SSD 10477 – Stage 3 Facilities Sydney Business Park, Marsden Park

ATTACHMENT A

Review of the engineering plans by Orion Consulting for stage 3 Sydney Business park, Project No. 20-0127, Set 02, Rev. A, Dwg. No. 000 to 602, dated 31.07.20 raised the following issues:

LINE A04

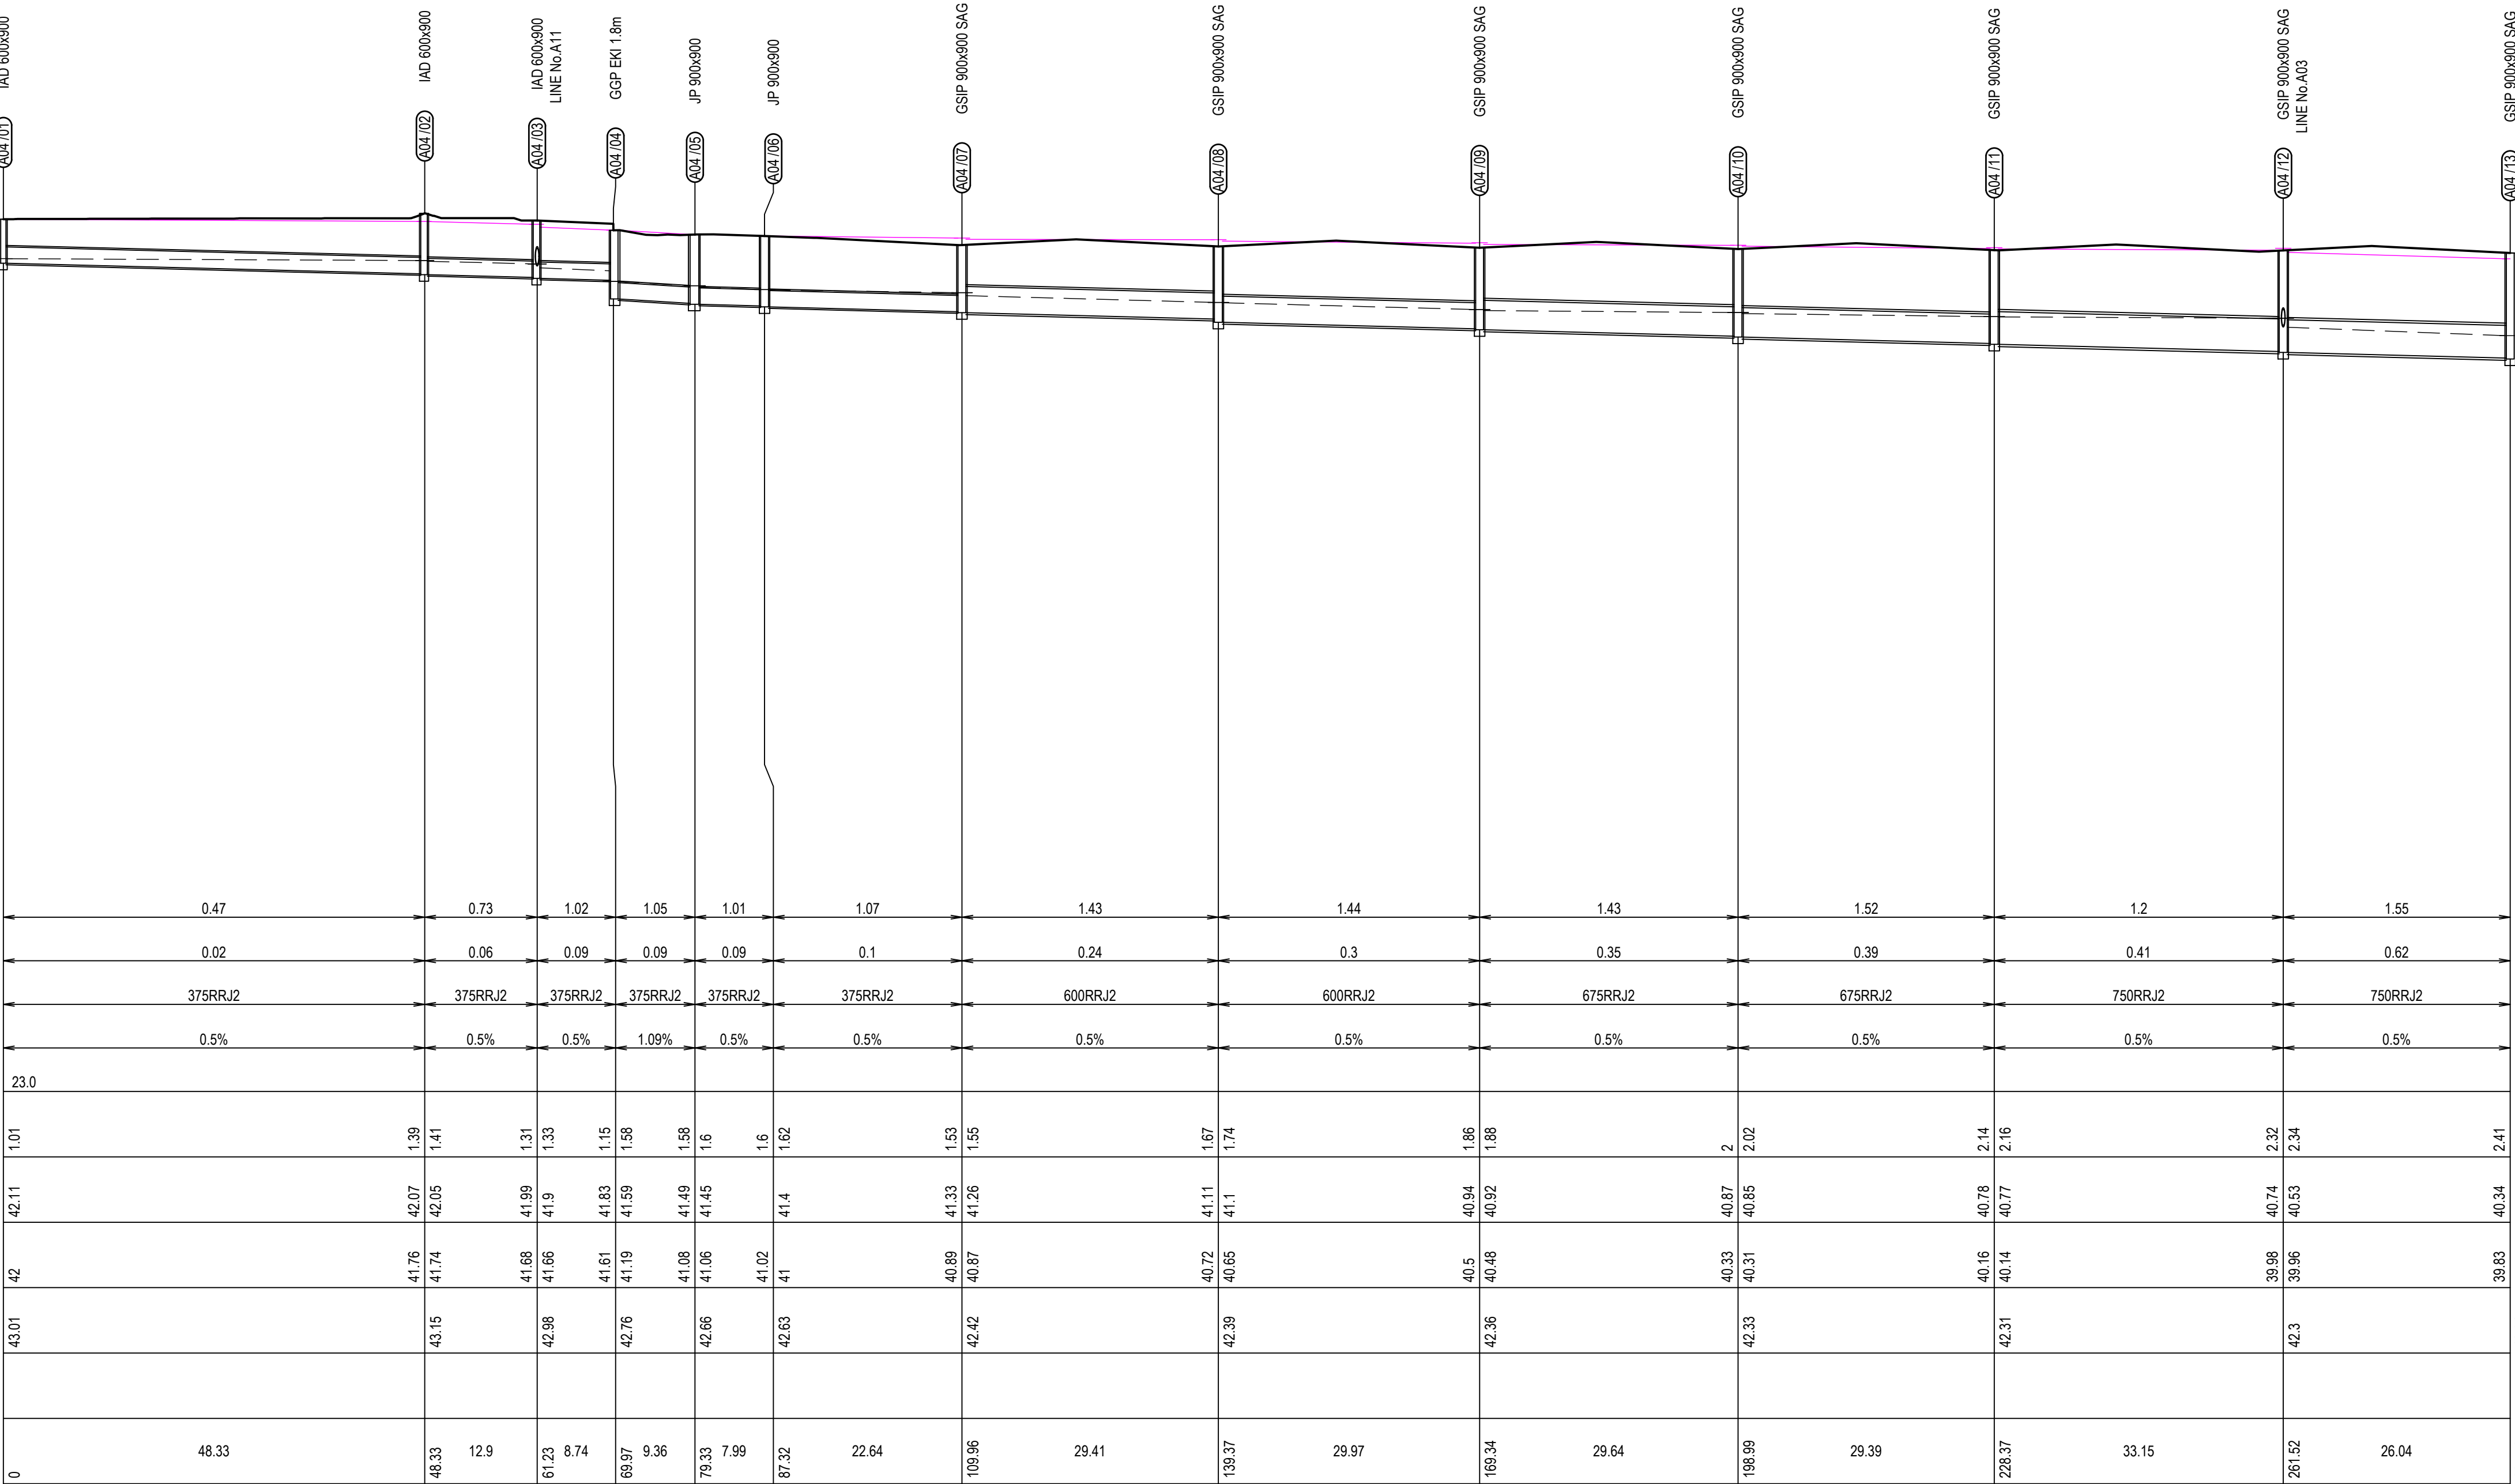
14. The HGL appears to show surcharge along most of drainage line A04 (Warehouse 1). To be addressed.
15. Driveway profiles required to be shown to ensure no vehicle scraping occurring as a result of the levels changes from the road into the carparking areas. Required for all warehouse driveways.

Title: ROUNDABOUT VEHICLE TURNING PATH PLAN SHEET 01 OF 03				
Project No.	Set No.	Milestone	Plan	Revision
20-0127	02	DA	600	A

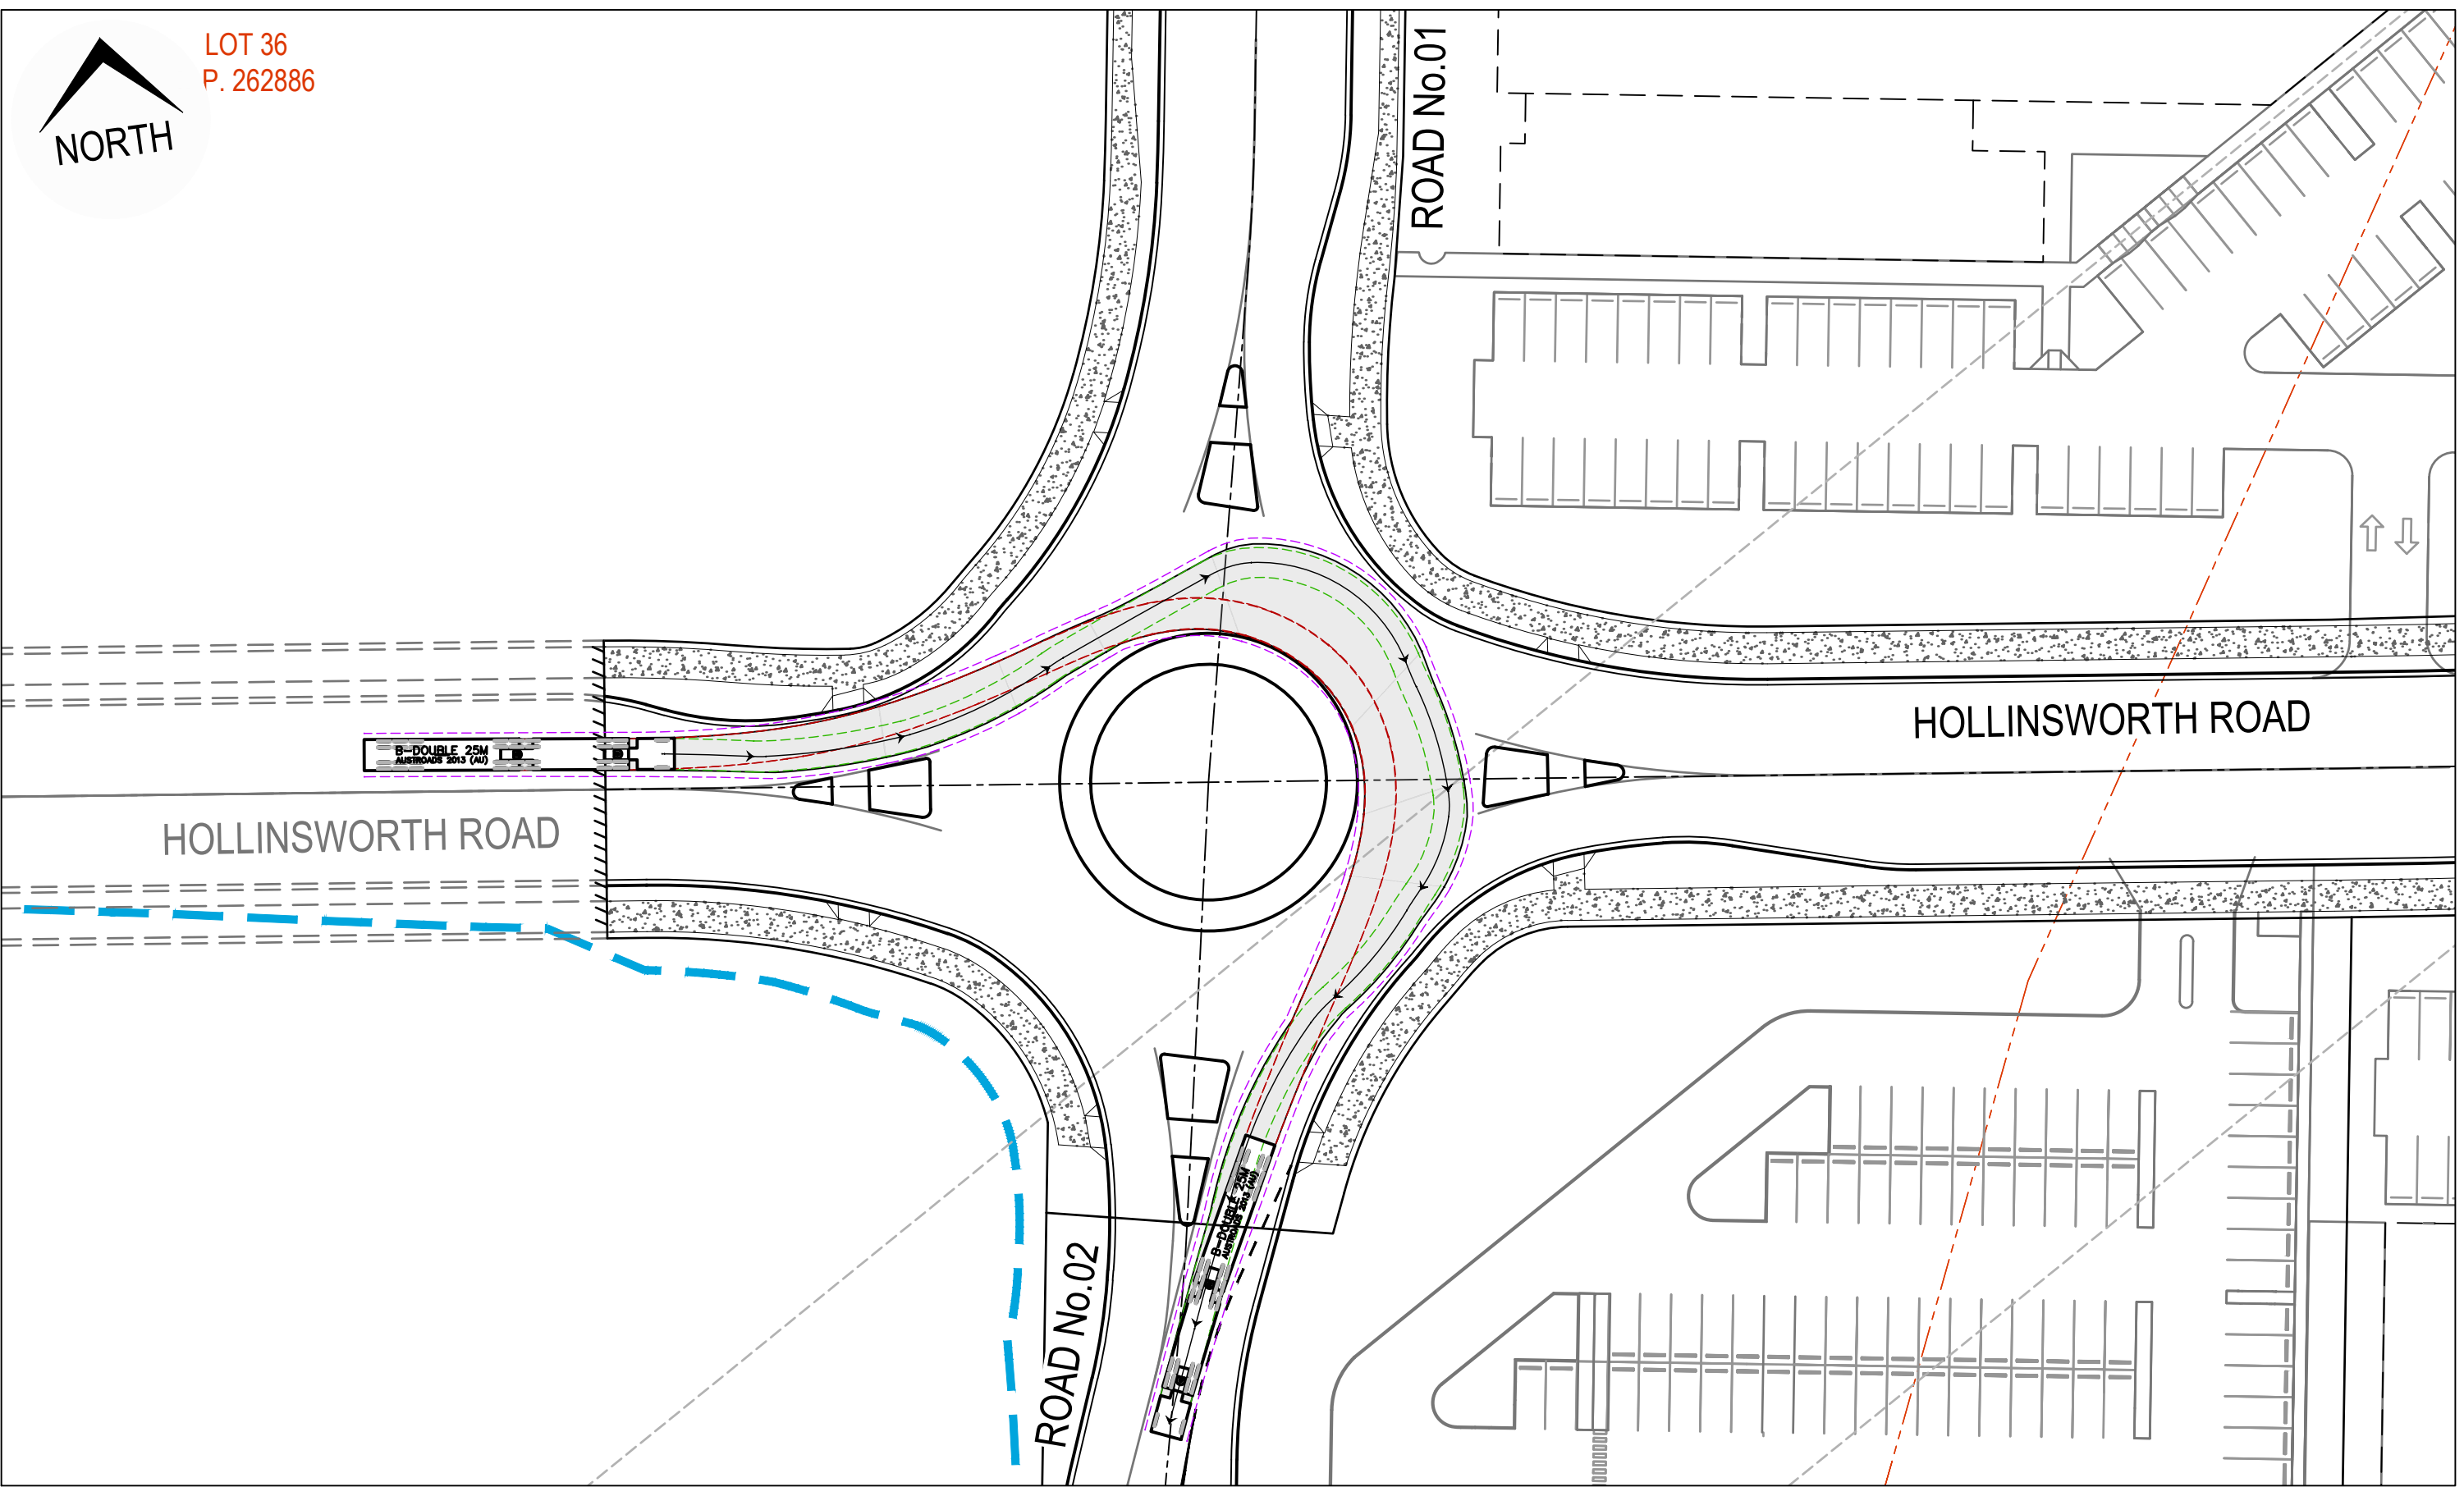
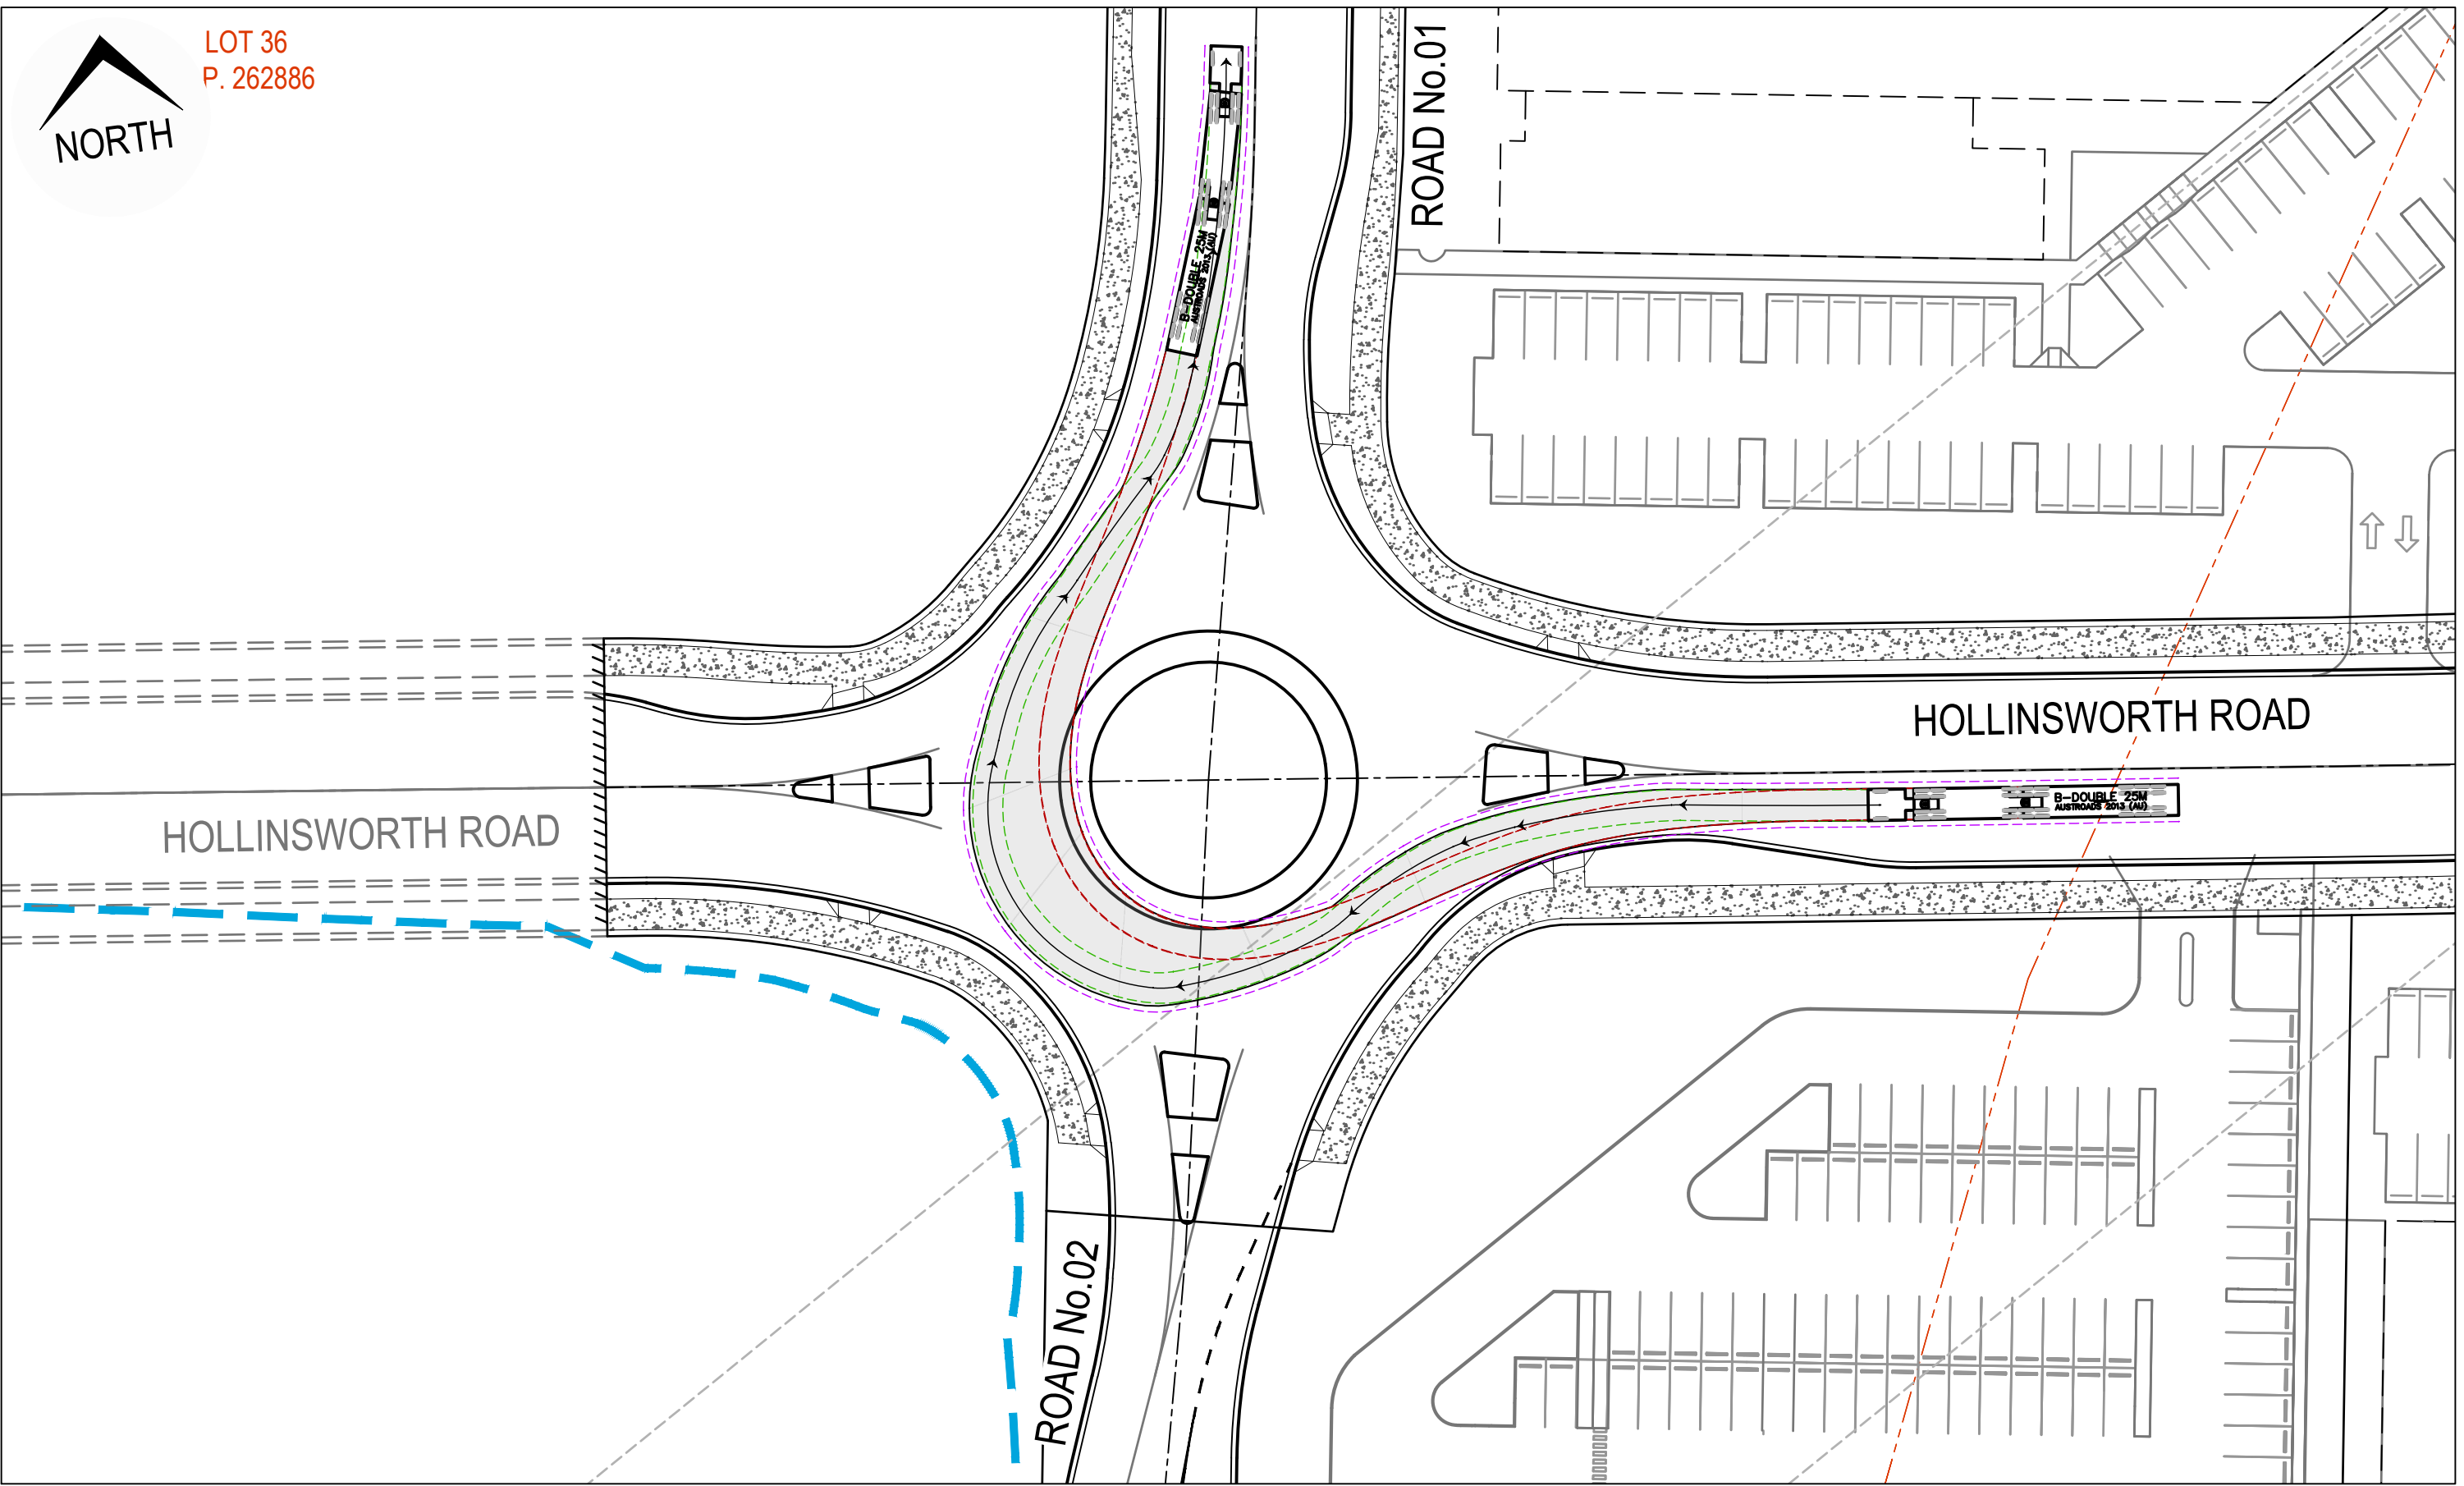
11. The design vehicle for the roundabout is a B-triple, for which turning / swept paths will need to be provided on a copy of the engineering plans. Council's Traffic team is to identify if the turning paths presented are compliant.
